Application No: WA/63/21/PL
Site Address: Land East of Tye Lane Walberton BN18 0LU
Description of works: Proposed alternative vehicular accesses off Tye Lane and emergency access off Avisford Park Road, along with minor highway works following WA/95/18/RES (resubmission following WA/93/20/PL). This site is CIL Zone 2 (Zero Rated) as other development.

Thank you for your internet representation made on 3rd August 2021 which has been recorded as an objection with the comments as follows:

A1 Scale	Date	Designed by
1:500	DEC 2020	KI
Drawn by	Checked by	Approved by
KI	KI	KM
Drawing Number	183248-003	
Rev	C

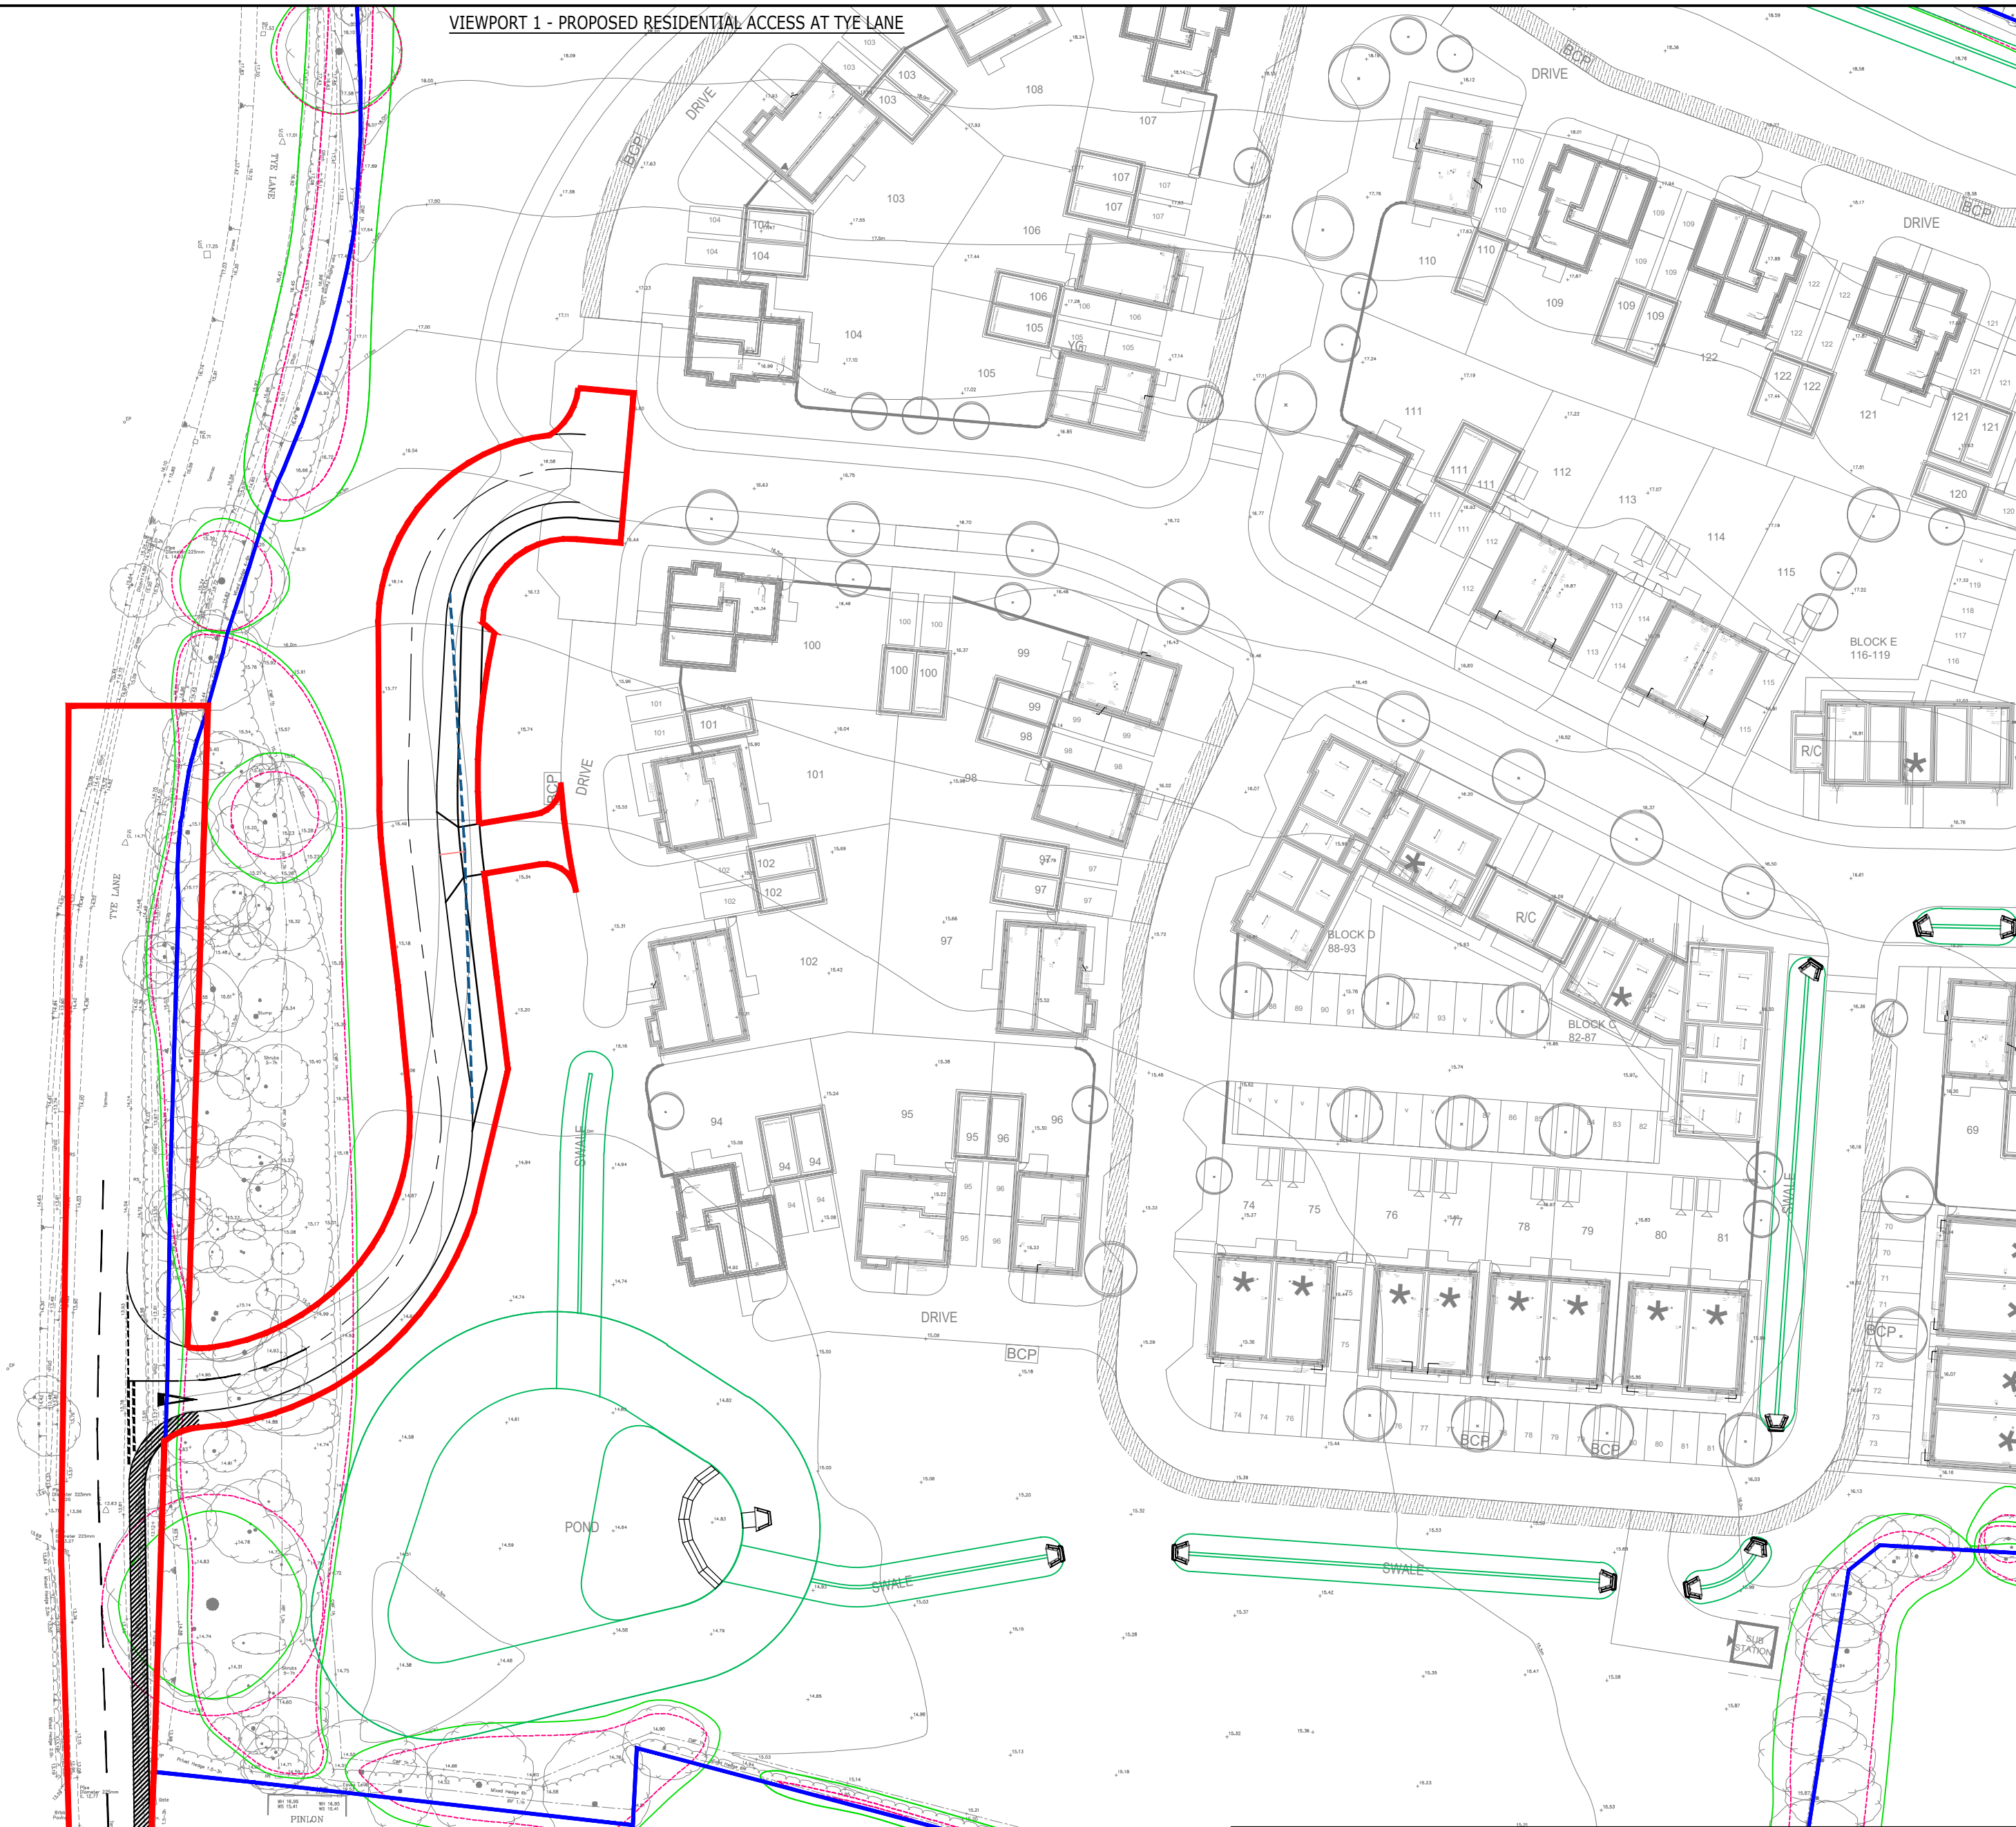
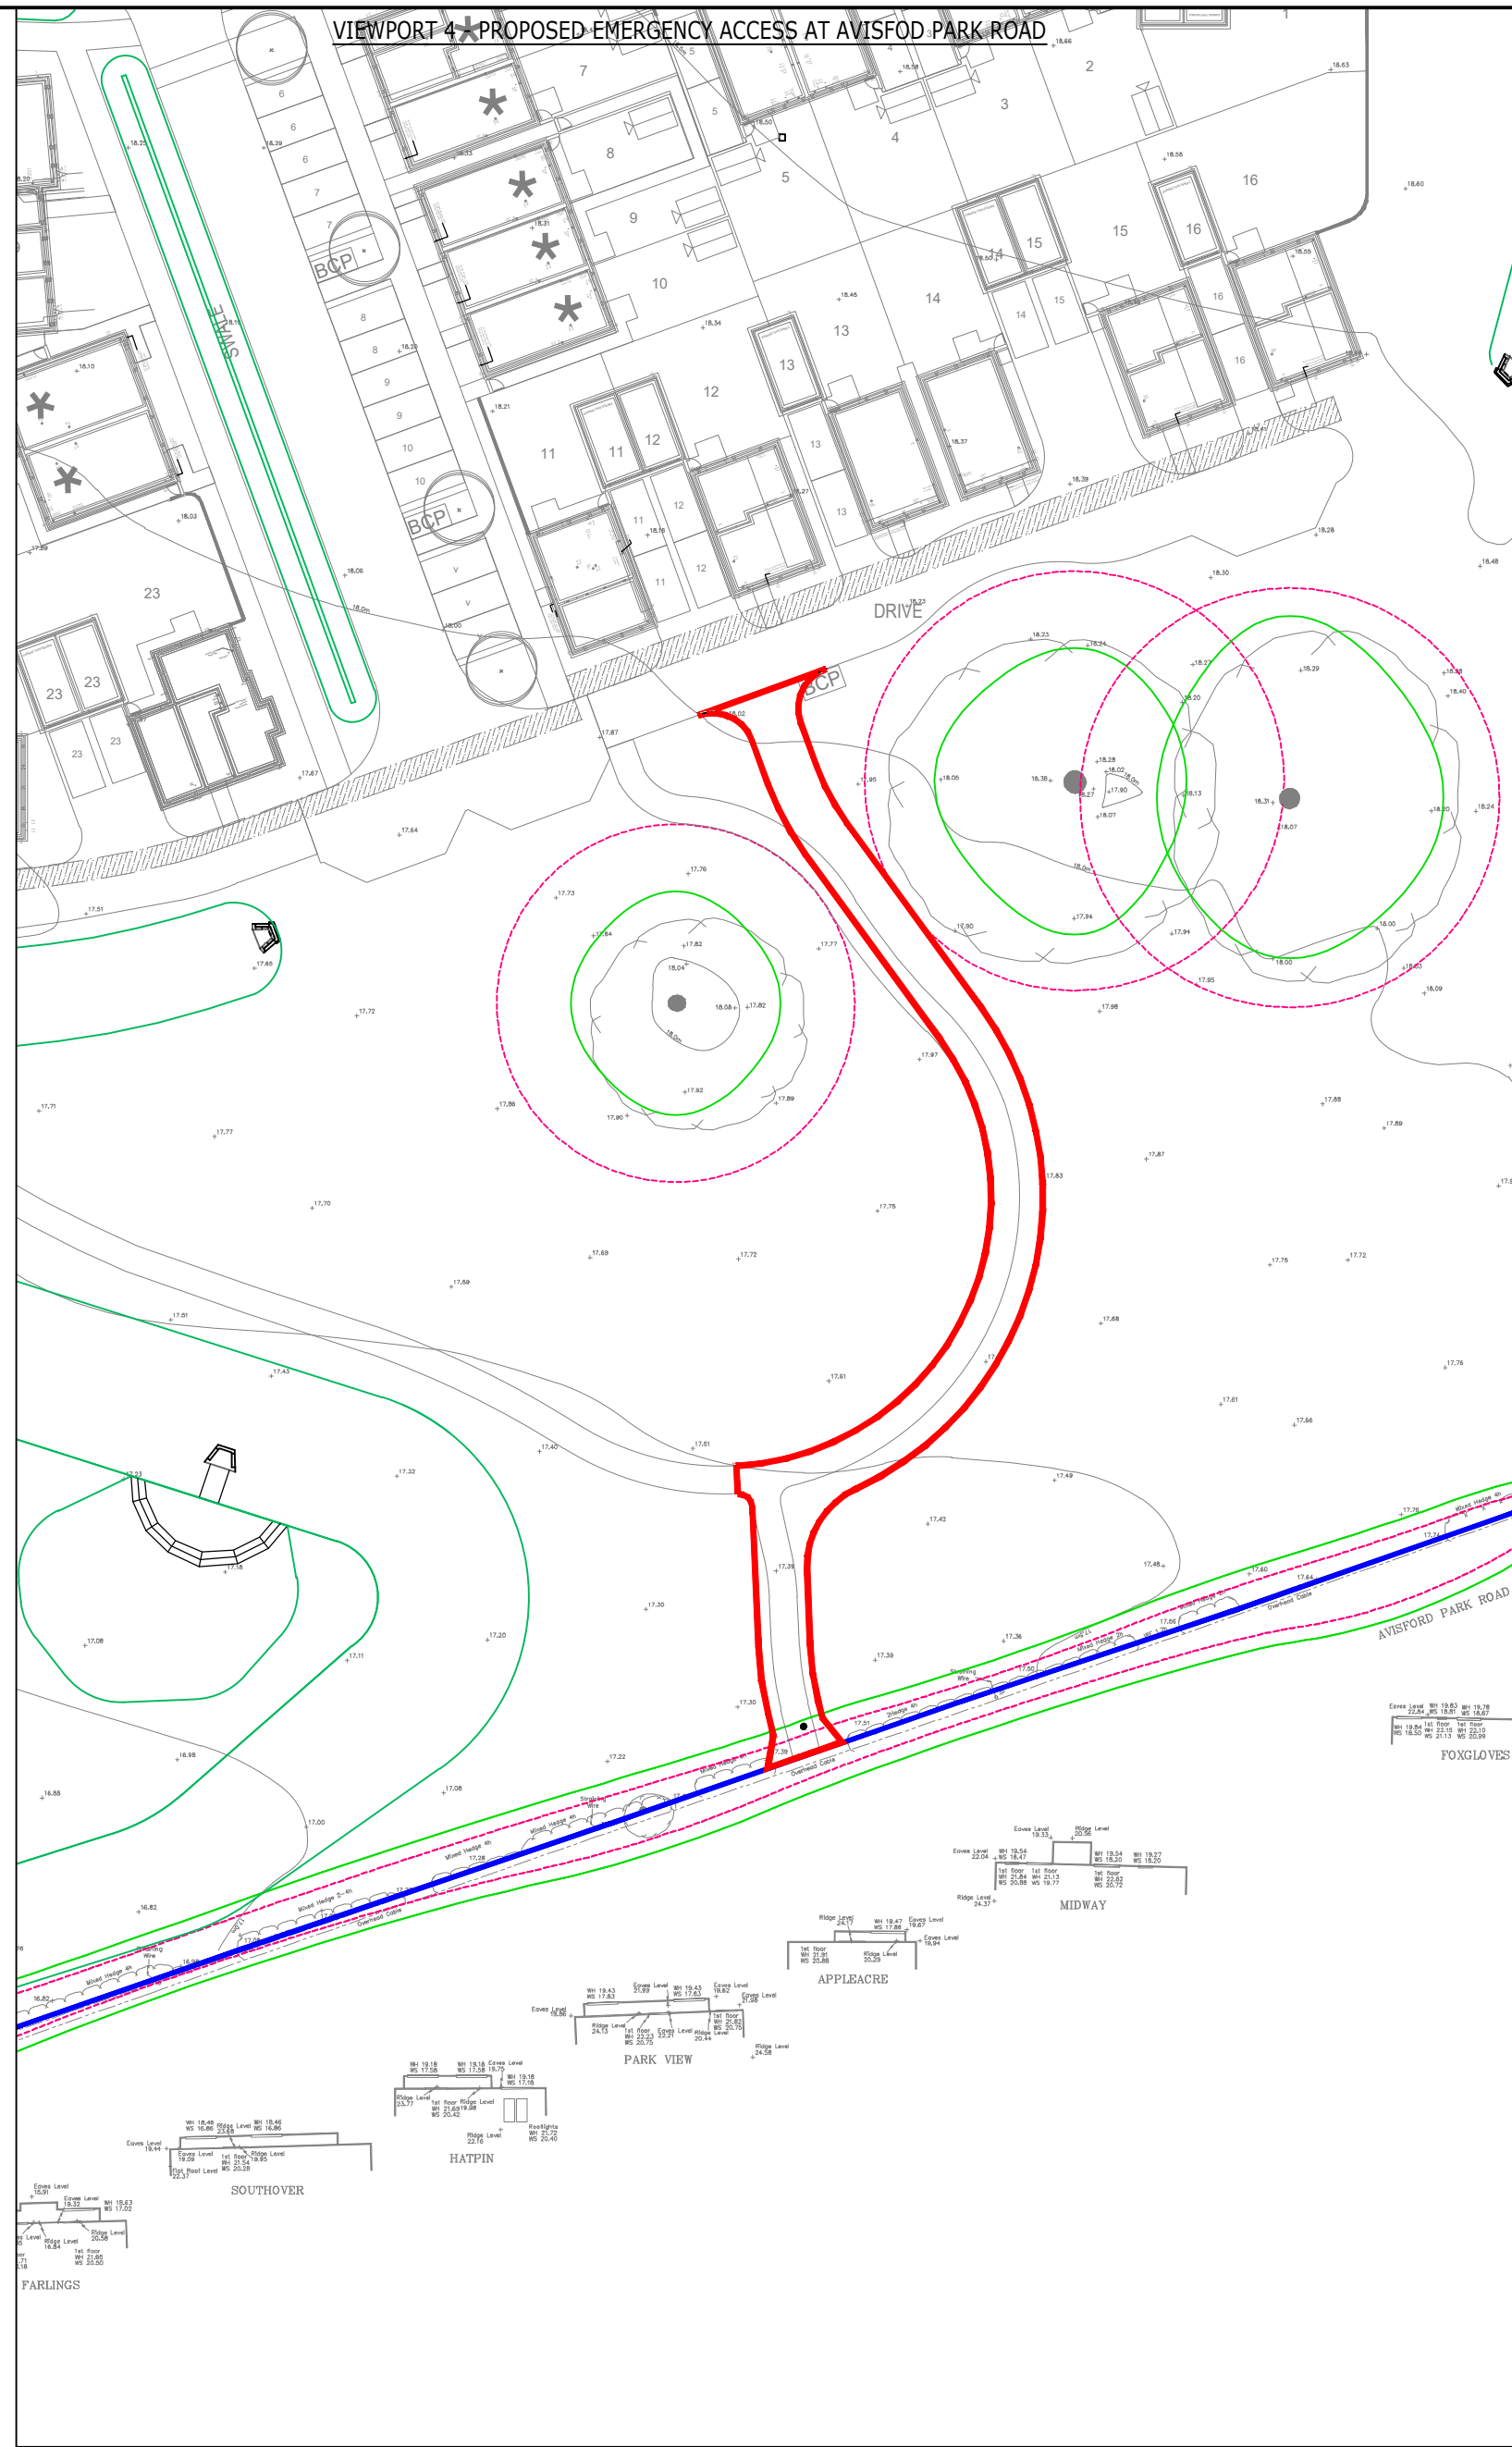
Tye Lane is significantly narrower than Yapton Lane for vehicle movements. The new application reduces Tye Lane to a minimum of 4.8m rather than 5.0m for approximately 25m which would mean that a HGV and a car could no longer pass at this point. 2 vans (2.4m wide) would be able to pass with zero clearance between vans and kerb and the vans themselves, encouraging vehicles to mount the pavement. 5 of the 6 houses at The Street end of Tye Lane have land ownership up to the current highway boundary. 2 of the houses do not have driveways or garages and cars are legally parked on the road further reducing safety if traffic along this road is to be increased. Parking on The Street can also impact on the visibility for vehicles pulling out into The Street at this junction.
